From: Anna Appleton
Sent: 31 August 2017 13:52
To: Richard Temple
Cc: Fiona Fitzgerald
Subject: Planning Application BR/199/17/PD - 5-7 Station Road Bognor Regis (C220043)

068_P_04

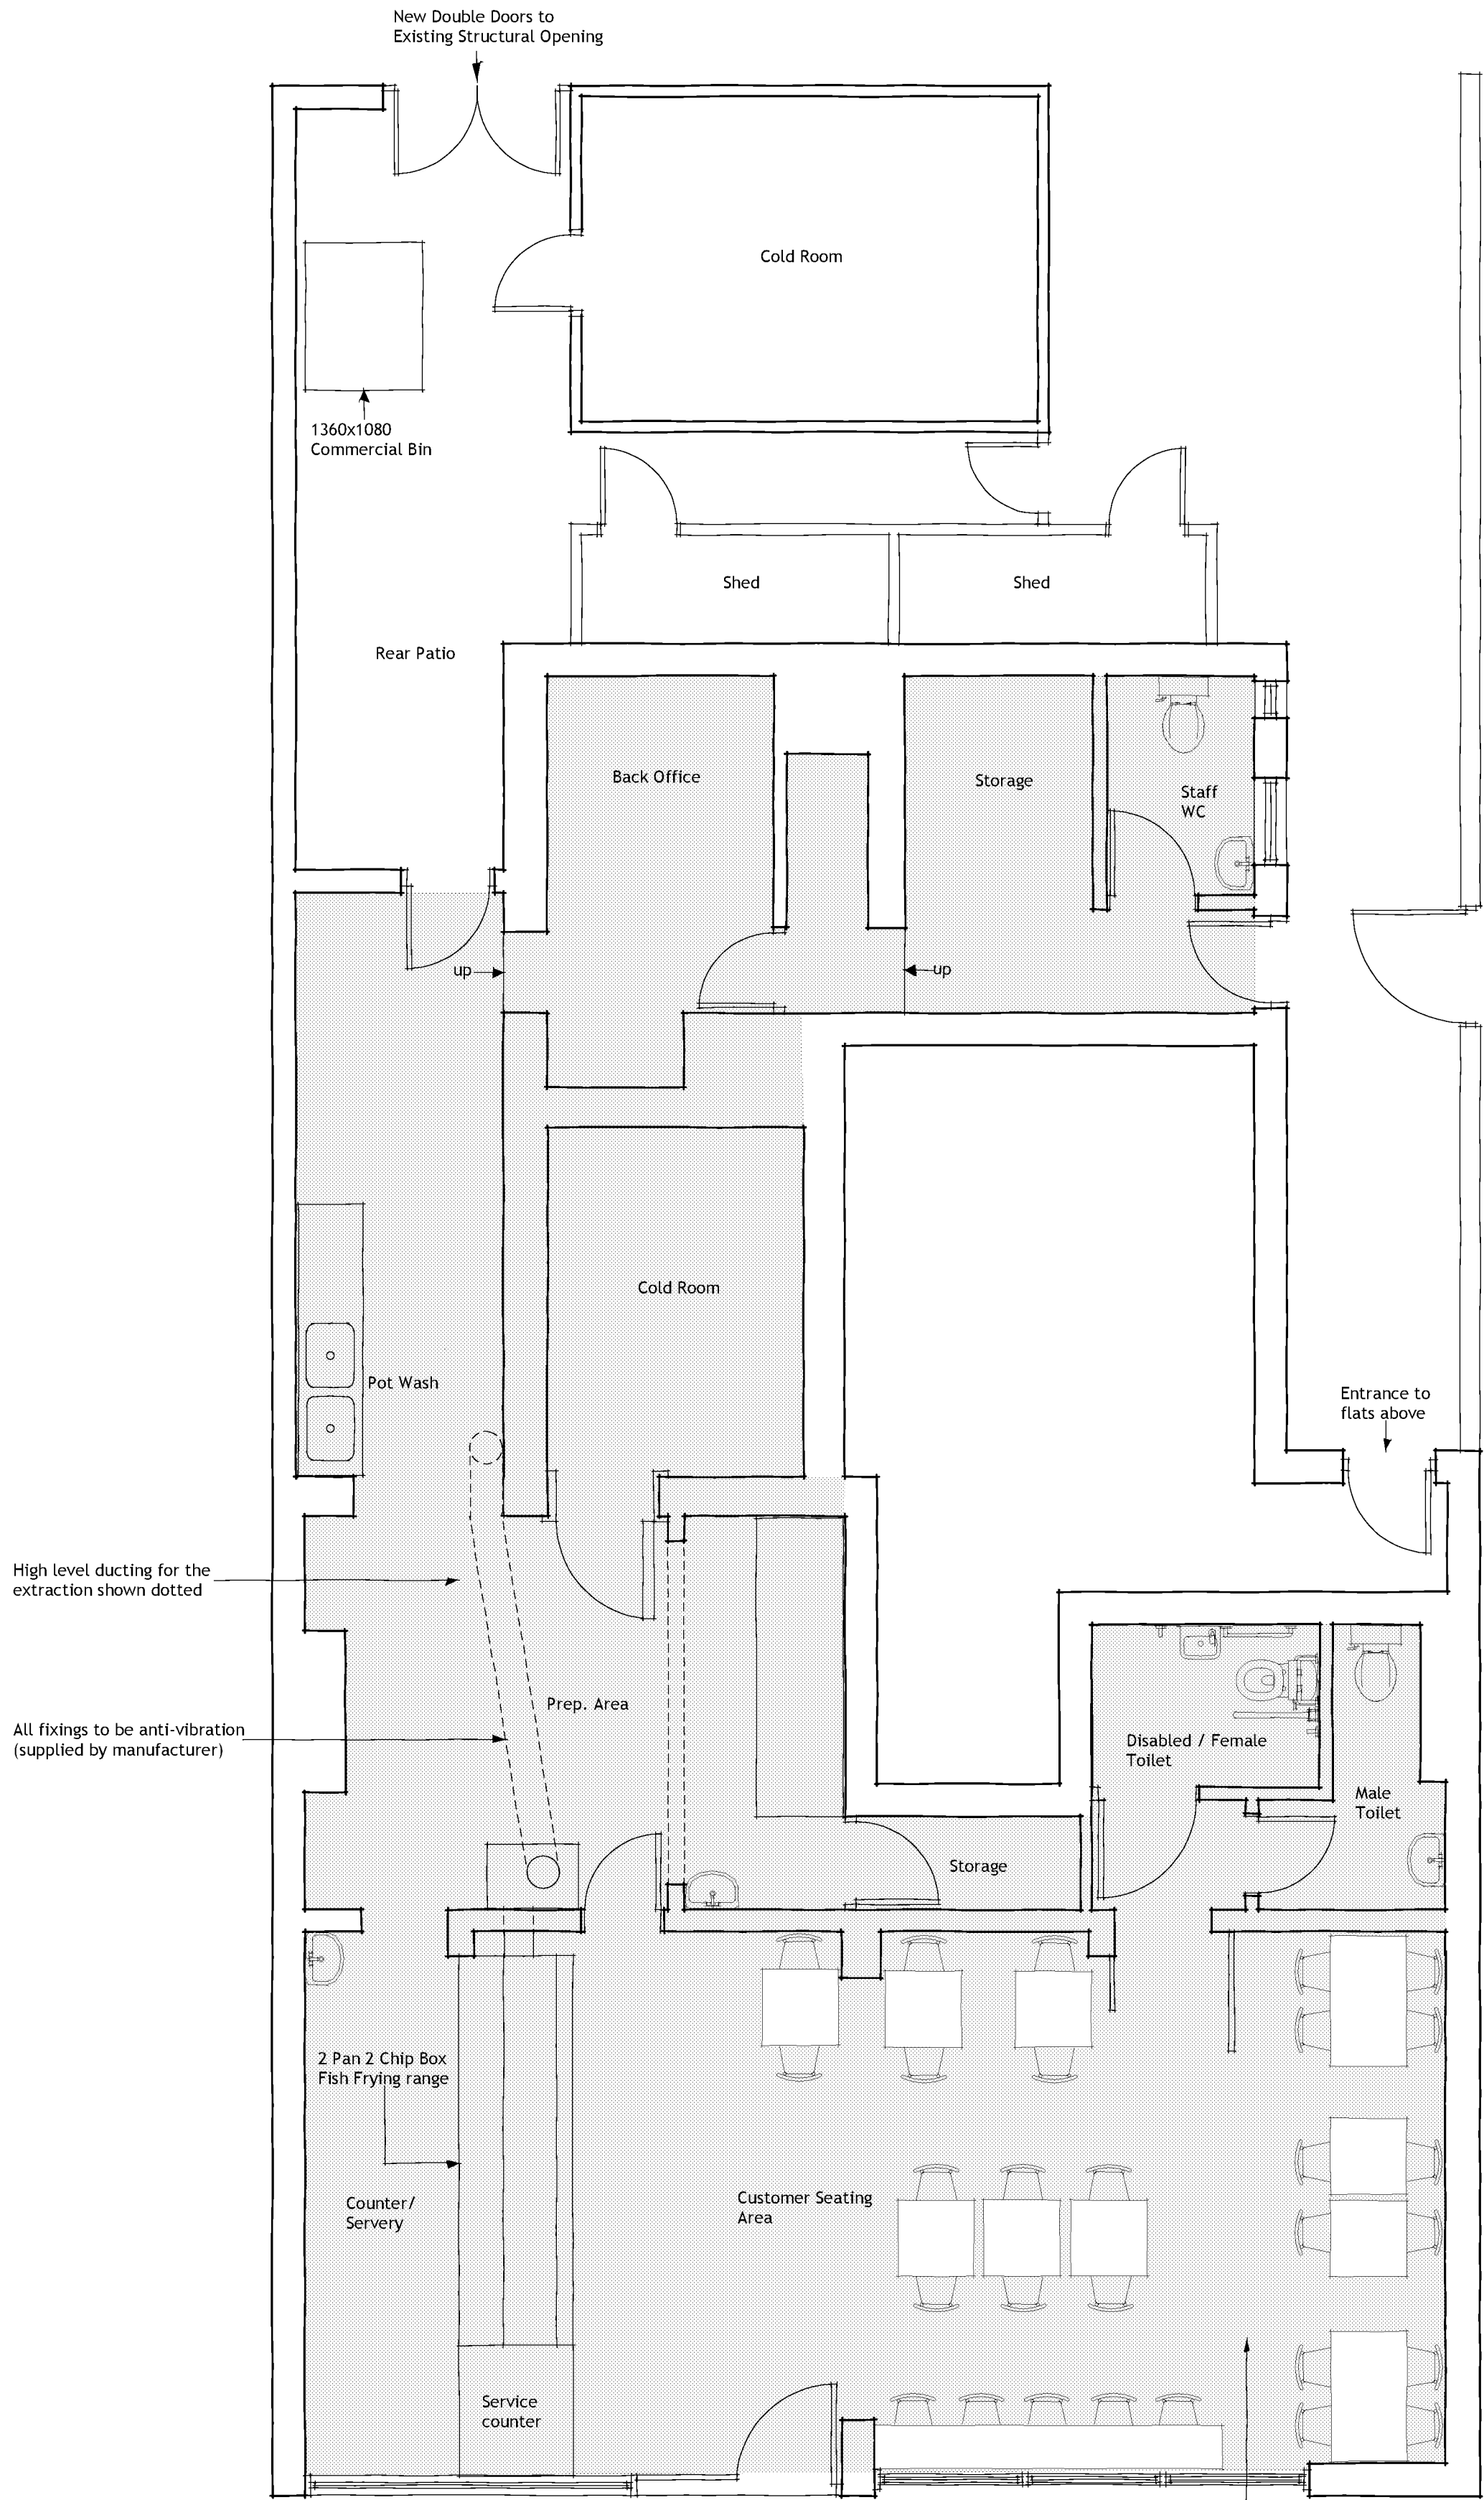
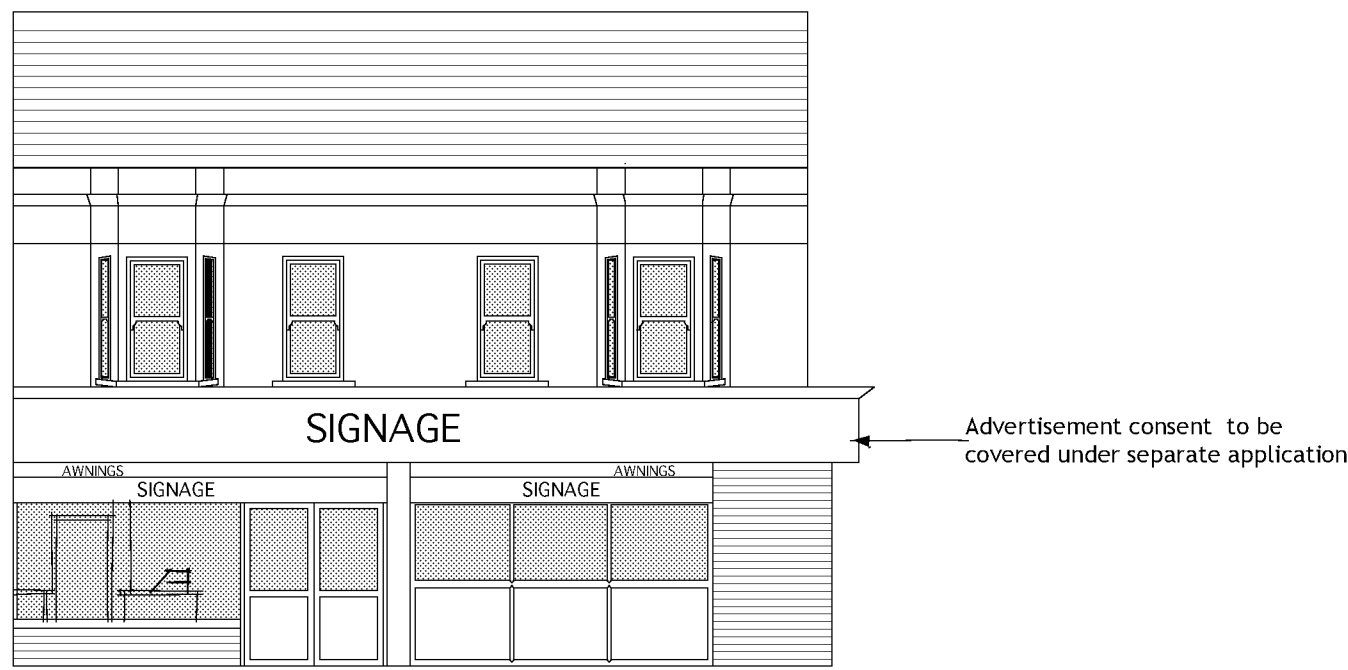
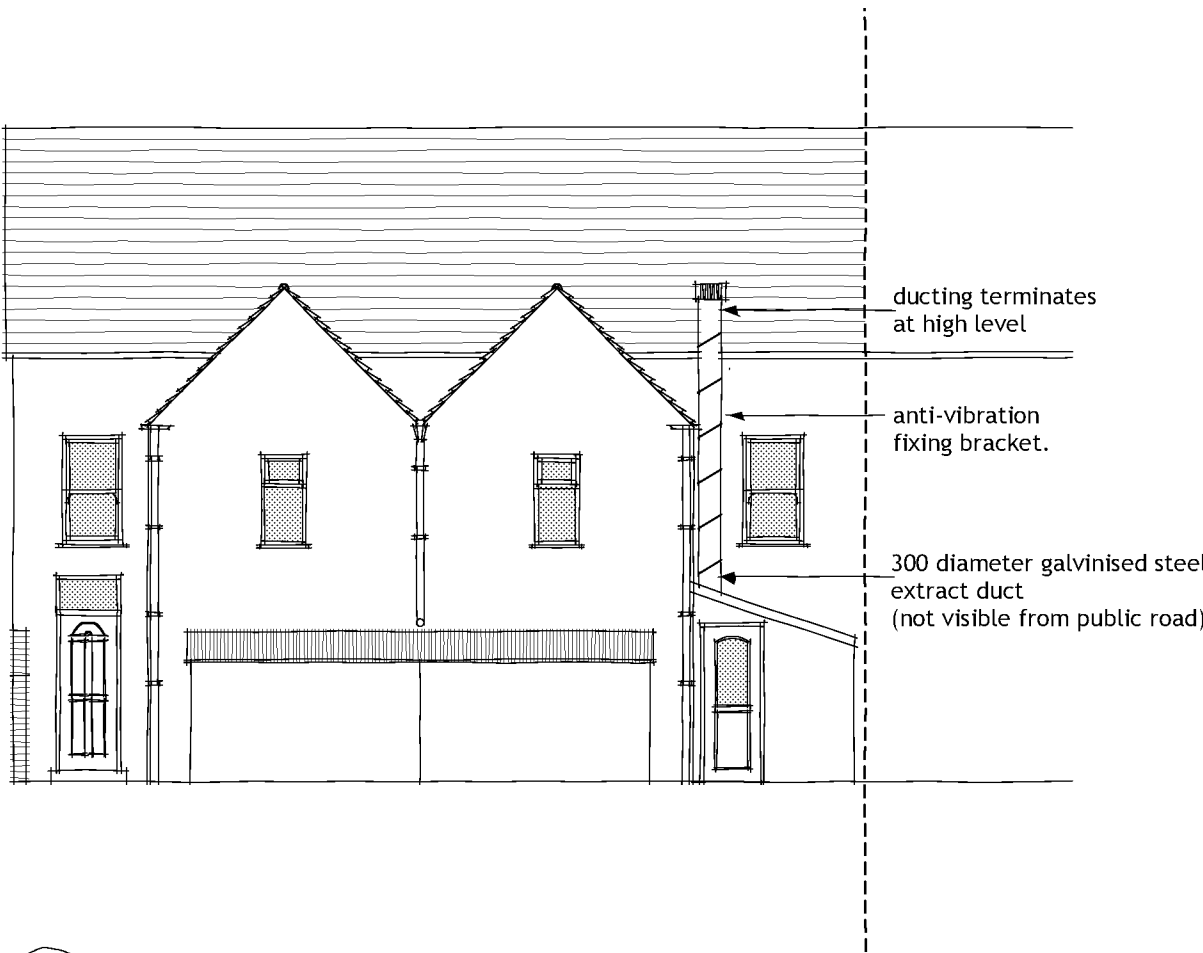
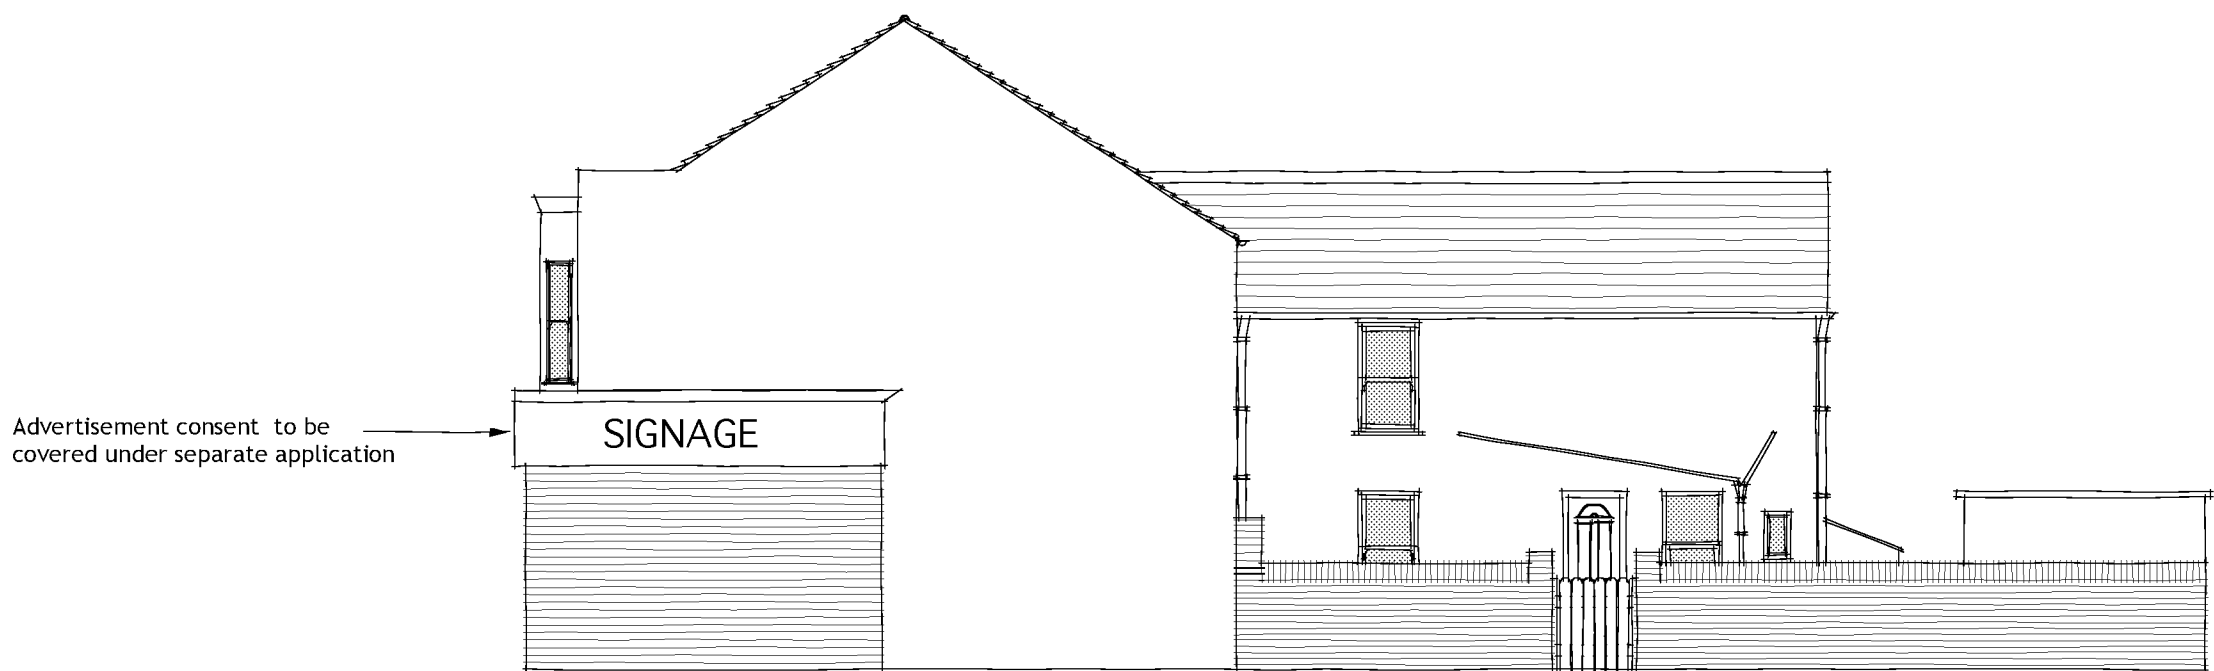
1. Before the use hereby permitted begins, equipment to control the emission of noise and odour from the premises shall be installed in accordance with a scheme to be first submitted to and approved in writing by the Local Planning Authority. All equipment installed as part of the approved scheme shall thereafter be operated and maintained in accordance with that approval and retained for so long as the use continues.
